## PLANNING CONSULTATION RESPONSE

<b>Application No</b>	2025/0912
<b>Proposal</b>	Erection of single storey side and rear extension and creation of parking facilities to the front of the property.
<b>Address</b>	55 Armroyd Lane, Elsecar, Barnsley, S74 8ET
<b>Date of Consultation Reply</b>	25.11.2025
<b>Consultee</b>	Charlie Atkinson Design & Conservation Apprentice

PROJECT	Extensions & Alterations	
CLIENT	Mr. & Mrs. L. Hollingworth	
TITLE	Elevations as Proposed	
ADDRESS	55 Armroyd Lane, Elsecar, Barnsley. S74 8ET	
DRAWN BY	ggg	
SCALE	1:100 @ A3	DATE Mar 25
DRAWING No	515-05	REV A

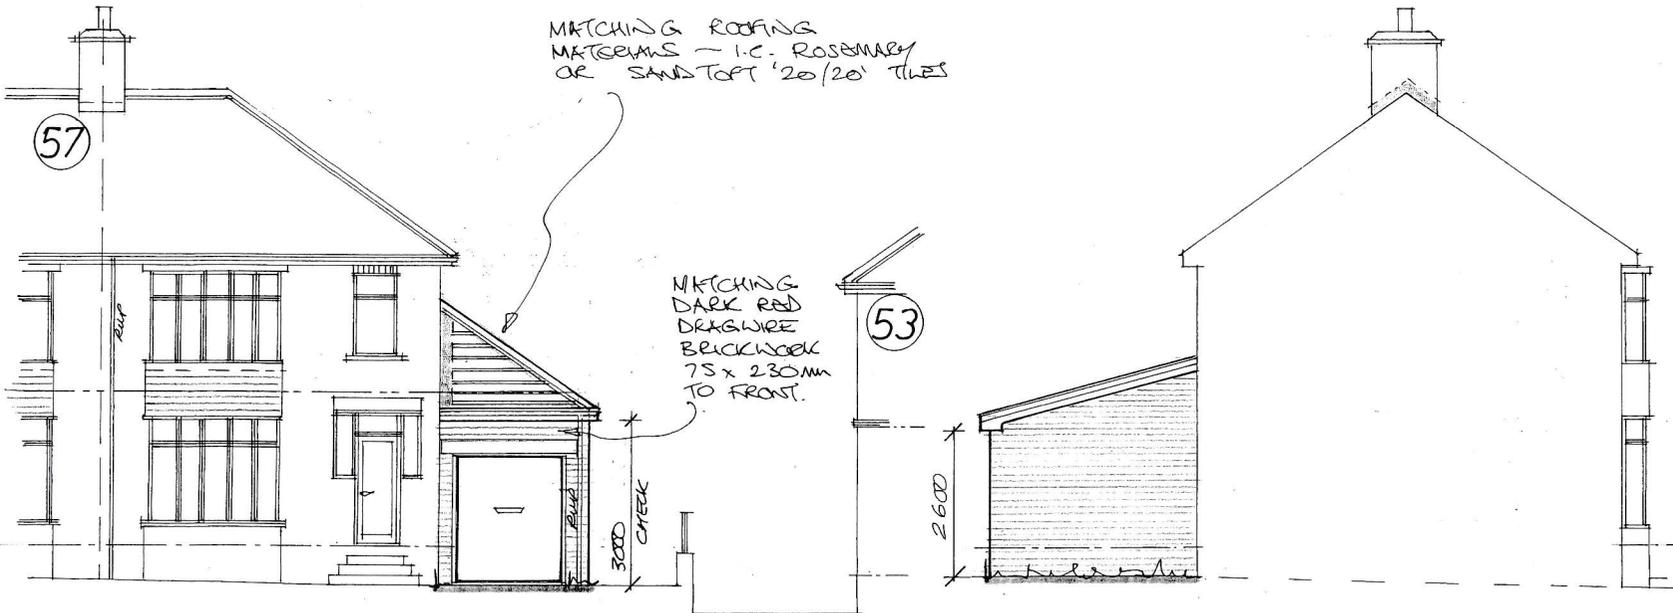
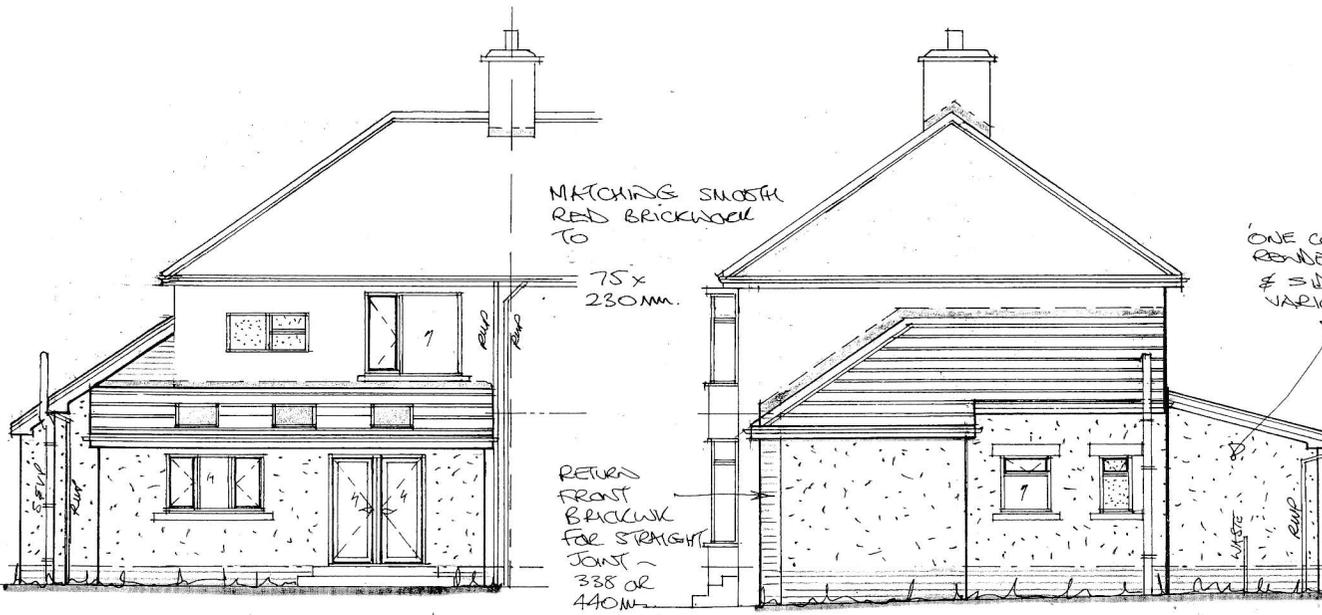
Due to cost considerations, the current proposal has been reduced to a single-storey side and rear extension. Previous comments regarding materials have been noted: the original scheme proposed Dark Red Dragwire brickwork. The revised proposal has respected this condition and has retained the dark red Dragwire brickwork on the front elevation but has introduced a one-coat render finish to the side and rear extensions, with matching roofing.

Although this change may seem minor, the introduction of render is considered out of keeping with the character of the conservation area and the architectural interest of this inter-war property. If the render was omitted and replaced with the matching brickwork consistent with the main elevation and wider building, the development would be acceptable from a conservation perspective.
